From: BRIAN MARTIN [REDACTED]
Sent: 25 November 2018 10:30
To: Charlotte Easton [REDACTED]
Subject: Re: AL/59/18/HH - Northfields, Hook Lane, Aldingbourne

I write to you regarding application AL/59/18/HH – Northfields, Hook Lane, Aldingbourne.

Drawing 3 / 4

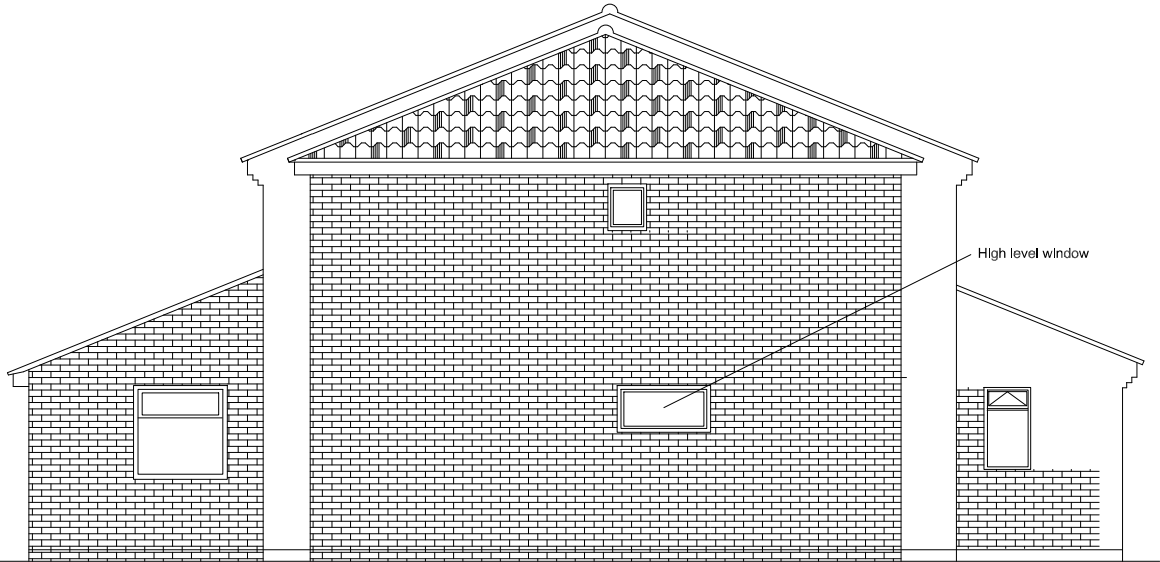
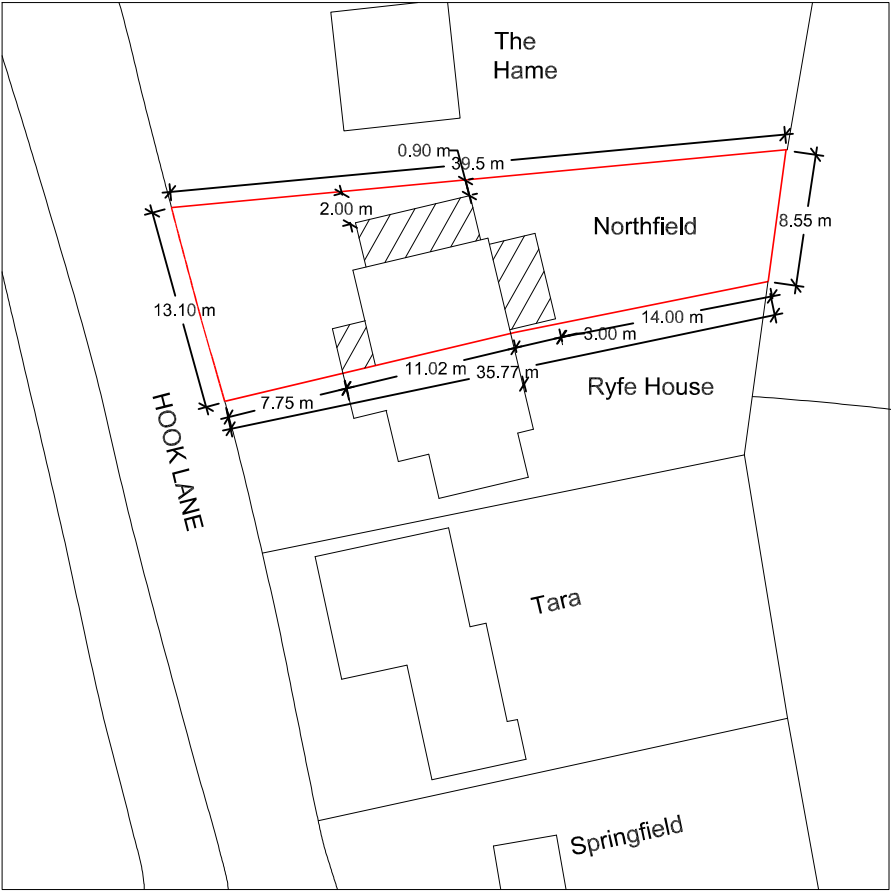
I have taken the file over from my colleague and just require some clarification on one of the drawings. There appears to be a discrepancy with the proposed elevation drawing ¾. The new East Elevation plan shows a distance of 0.7m between the highest part of the proposed side extension and the top of the existing roof, however, the new North Elevation indicates there only to be 0.3m, the elevations look quite different on the plan.

Could we please therefore request you amend the drawing and send in a revised version.

Revised plan attached mistake corrected.
